Daniel Matthew Tyndall, P.E.  
908 Westland Ridge Rd  
Fayetteville, NC 28311

September 12, 2024

Re: Change in Field Conditions – Main Entry and Covered Porch  
479 D.L. Phillips Lane, Broadway, NC 27505

Verification of a field change reference to drawing sheet S-4 has been requested by the owner.

FLOOR FRAMING PLAN - ENTRY / SUNROOM

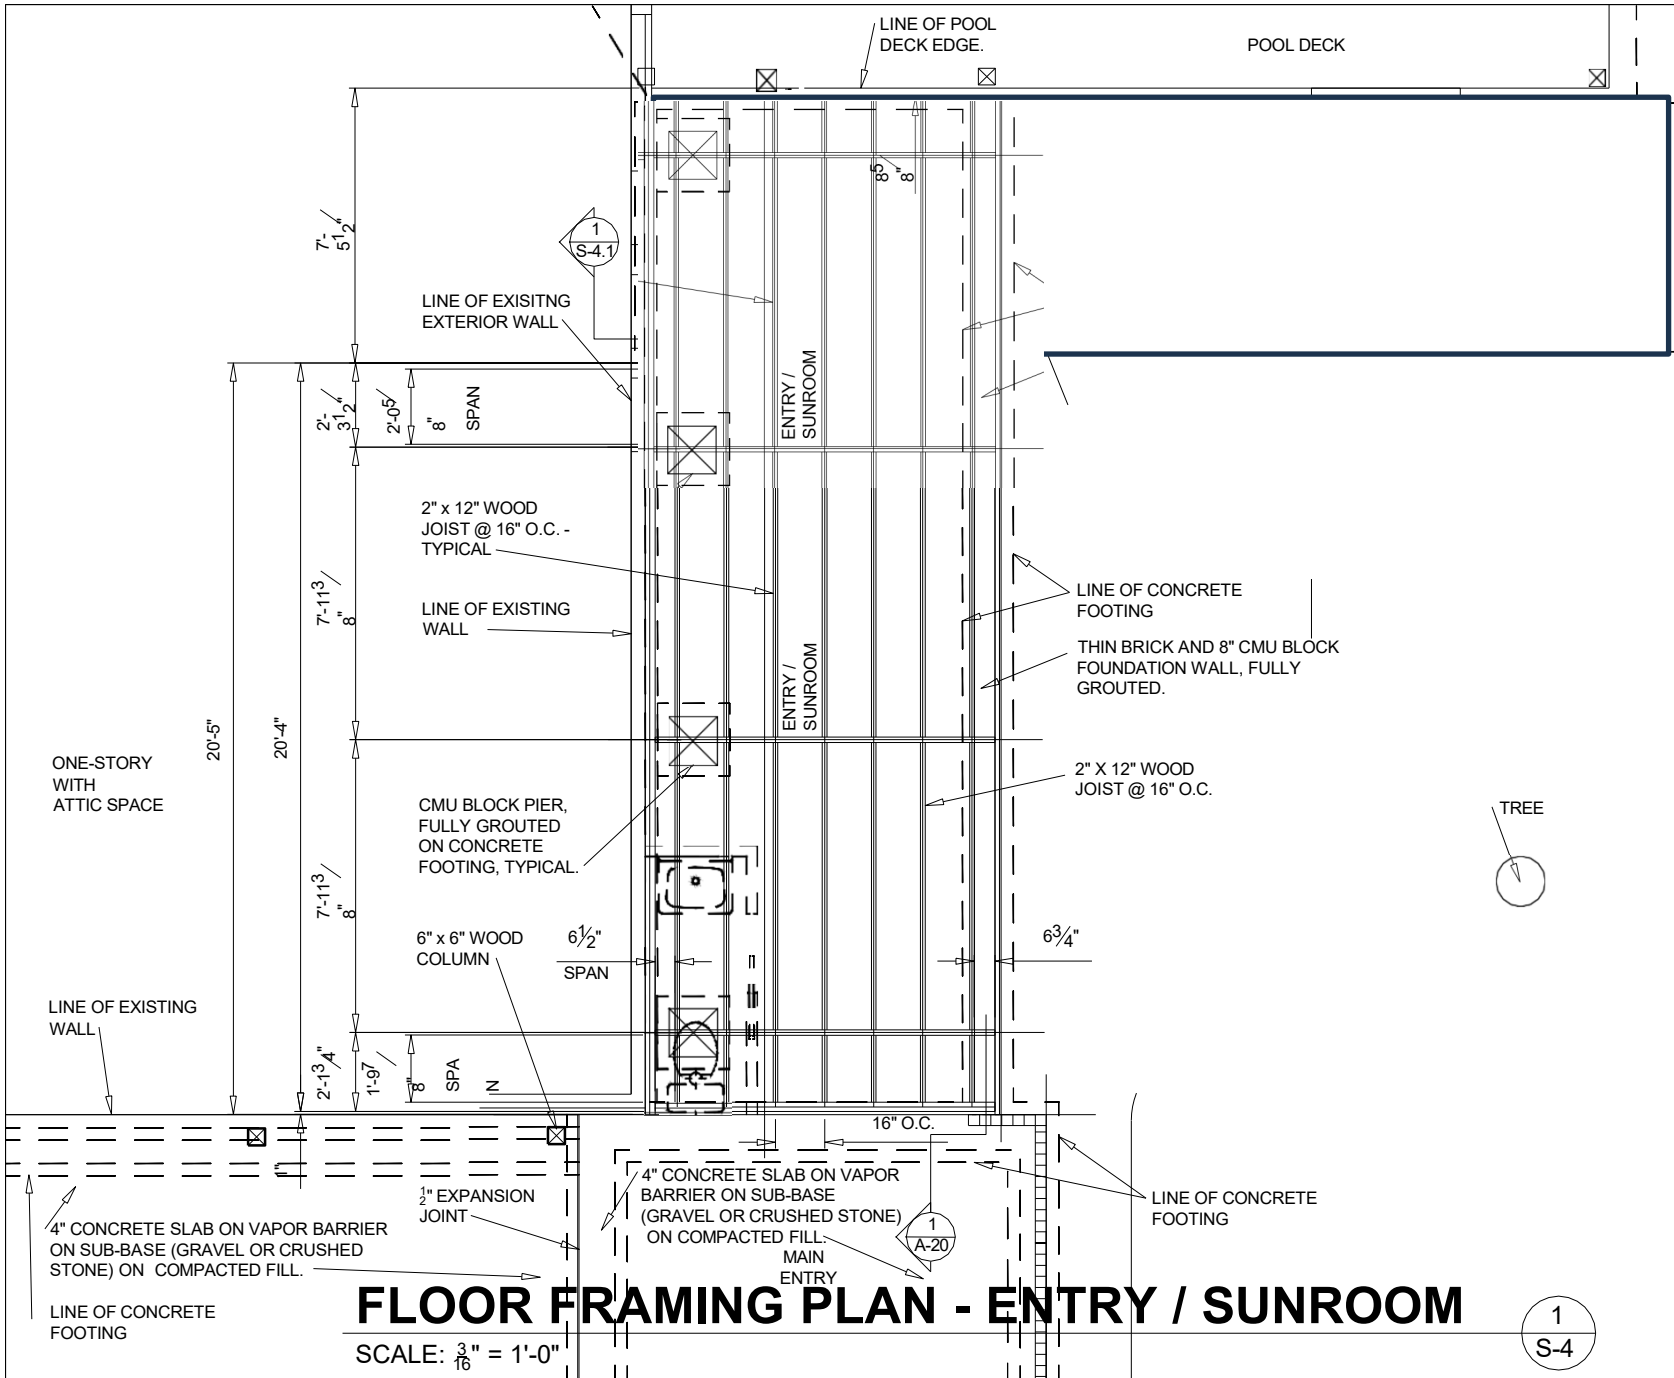
Current field conditions have installed 6 total piers in-lieu of the 3 original piers and extended the framing plan 7'-5 1/2" to existing pool decking. The current spacing of piers is an acceptable change from the originally shown S-4 drawings as the maximum on center spacing of 7'-11 3/8" is met with the current field conditions using a max clear spacing of 5'-3".

Based on current pier locations and heights, girder spans have increased from 9'-8" to 11'-1" and requires a 14" x 2 1/4" notch at the point of bearing in the designed (1) 1.5E 1 3/4"X16" LVL. The LVL modifications listed in this document and new span lengths meet ASCE 7-22 and other applicable building codes.

Beam Properties are to remain  $F_b=2250$  psi (bending stress rating) and  $F_v=285$  psi (shear stress rating) and shall be in full bearing (14") at each pier. Provide a continuous load path from 6x6 post to the foundation using two (2) No. 2 2x12 squash blocks directly under each 6x6 post and in direct contact with the (1) 1.5E 1 3/4"X16" LVL. Restrain ends of beam from rotation.
